Matthieu Santos
Senior Planning Officer
Department Planning Industry and Environment

300 Burns Bay Road -Early Works (SSD – 85848713)

Tree Location Plan-Appendix 2

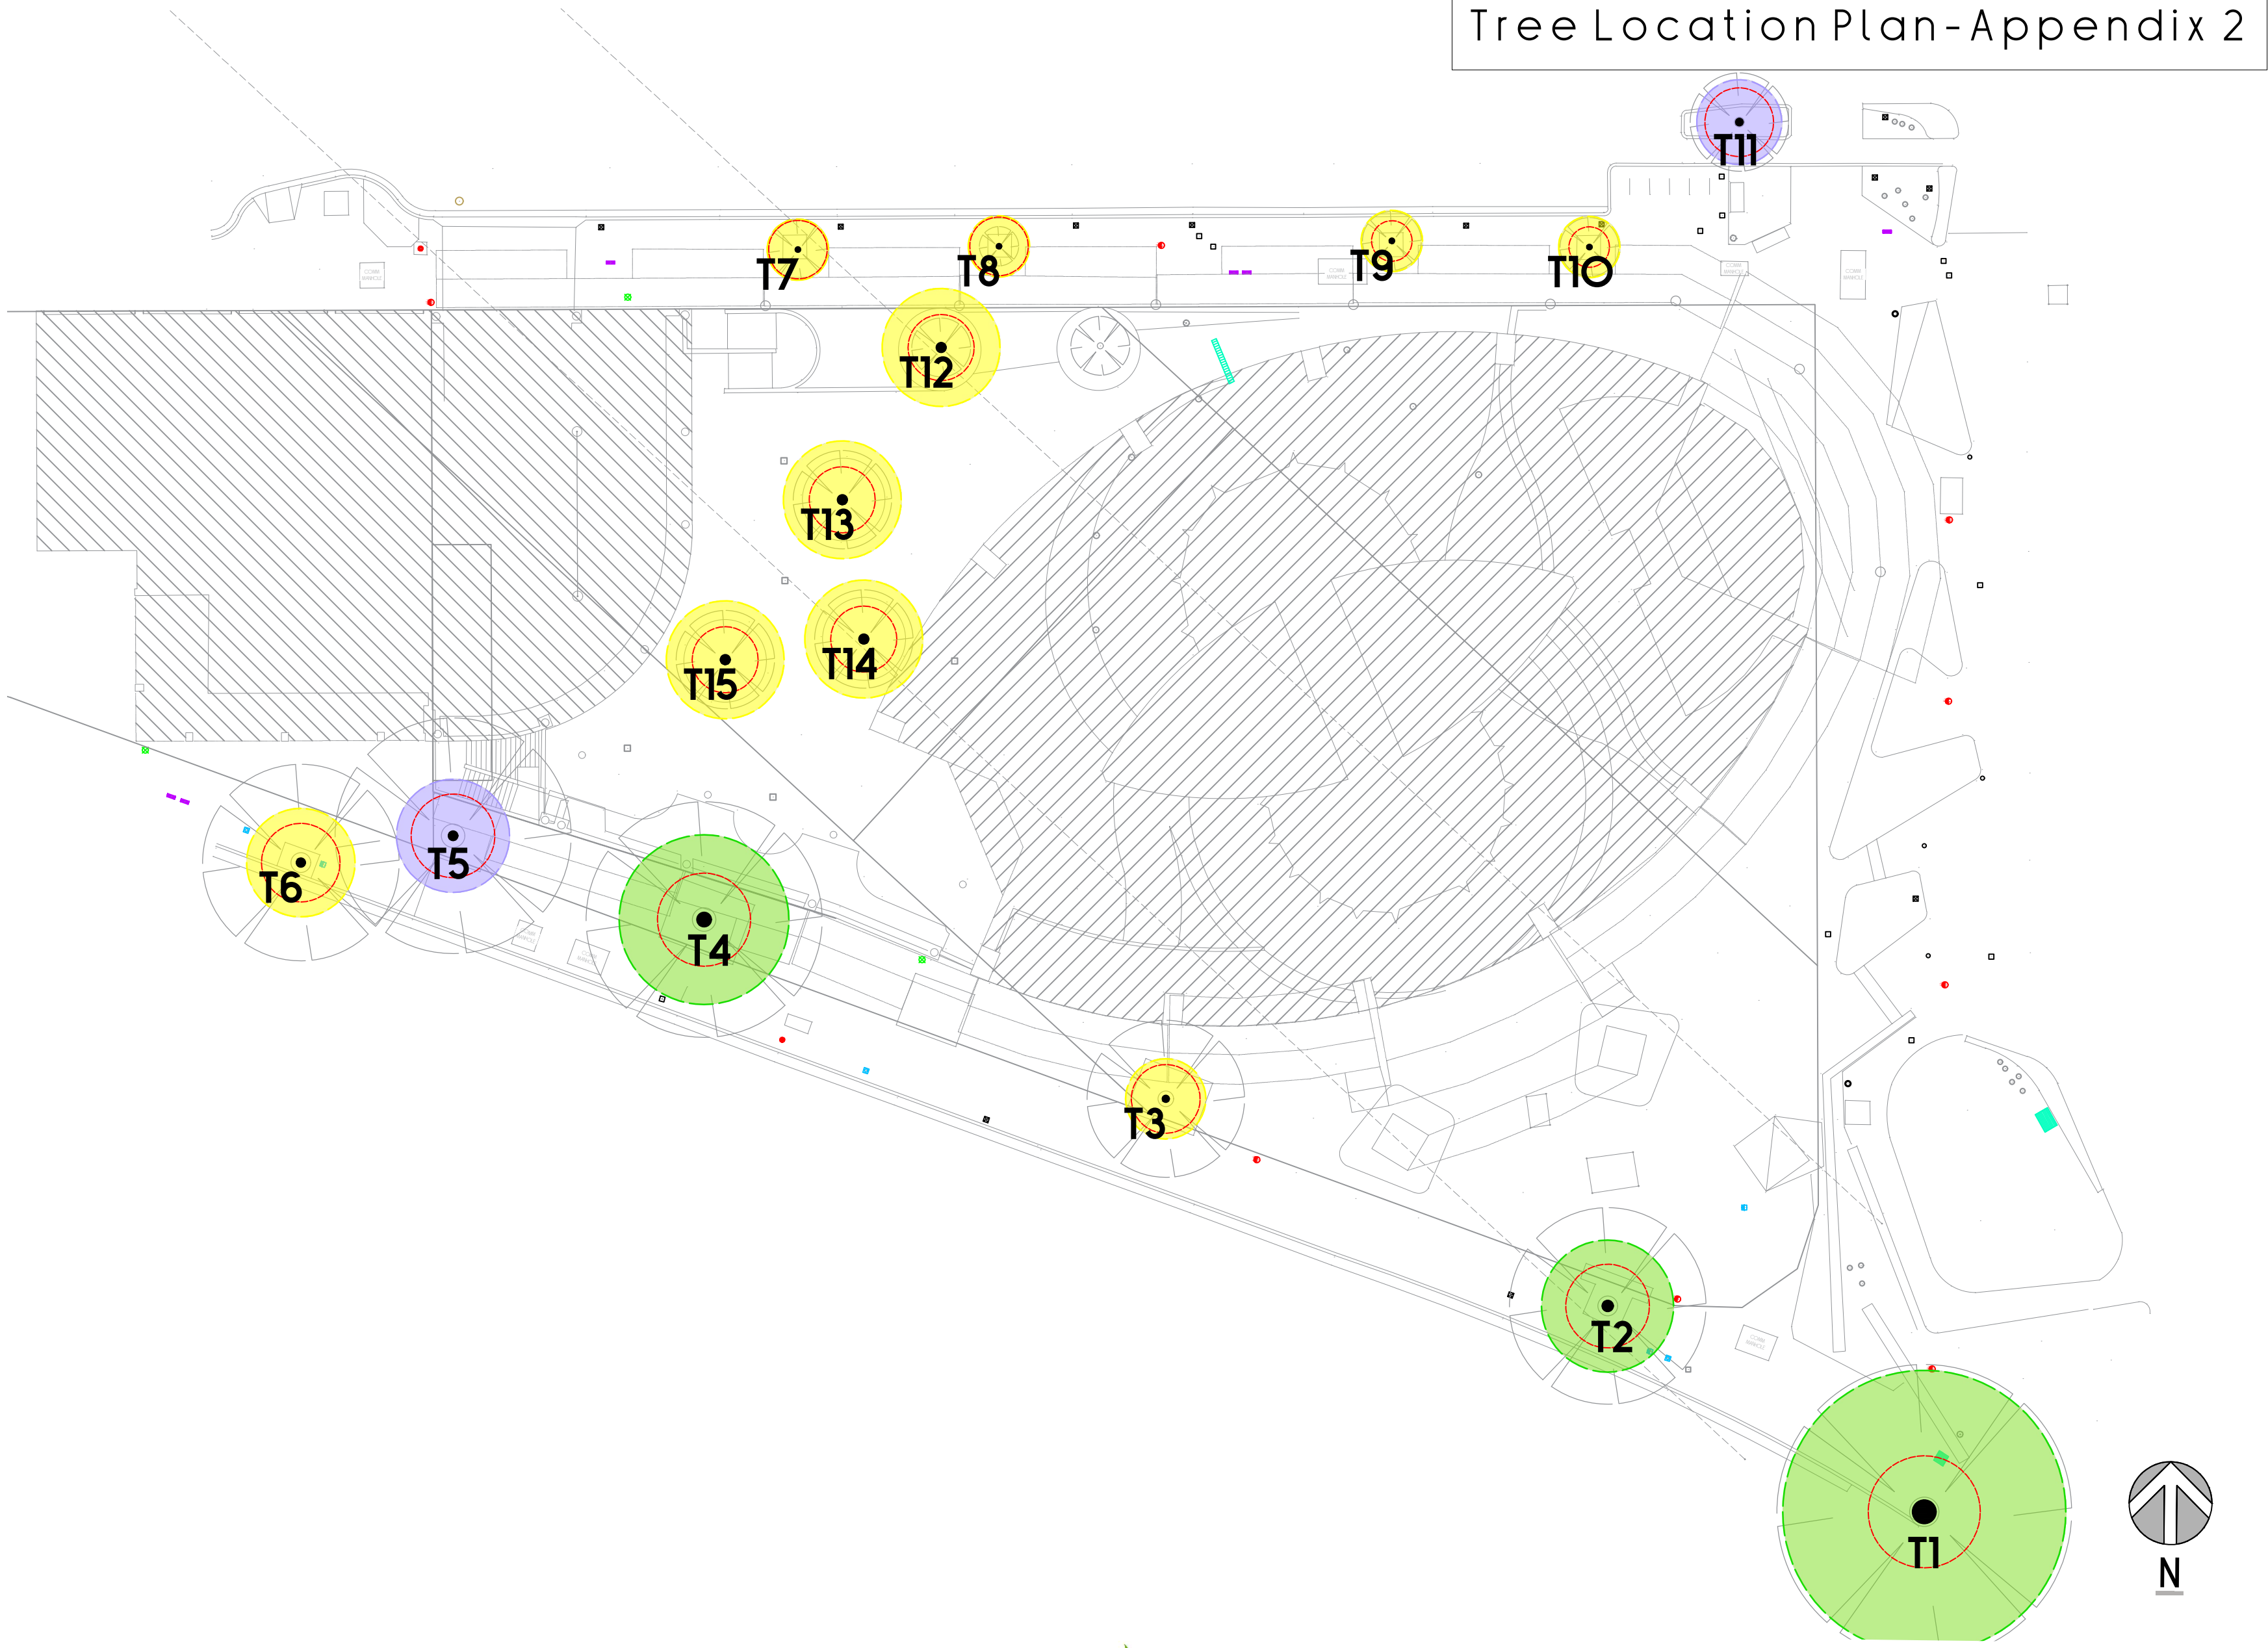
The trees to be removed include 10 medium and high retention value trees including: Trees 35, 36, 39, 40, 37, 57, 58, 59, 60, 61.

The removal of the medium and high value trees is not supported by Council. It is noted that no DA approval has been granted for the re-development of the site, therefore proposed removal of the trees is considered premature. The built form including building setbacks have not been approved. In particular, the 14 trees adjacent to the southern boundary could be retained if greater building setbacks were required.

In terms of retained trees, the arboricultural report discusses retaining 34 trees on neighbouring properties. These trees inflate the overall tree numbers and should not be included in the net calculation. The applicant does not have owners' consent to remove or prune any trees on neighbouring properties in any case. The proposal would retain only 19 trees on site and only 727m² of canopy cover.

- There are also minor discrepancies between tree retention and removal within Arborist report, landscape and demolition plans.
- The applicant to consider larger replacement planting within western setback (I.E advanced *Syncarpia glomulifera*) to offset loss of trees within the site.

In light of the above, it is recommended that the tree removal component be removed from the early works DA. Tree removal should be only considered under the re-development and rezoning application for 300 Burns Bay Road (Ref: SSD- 87925706).
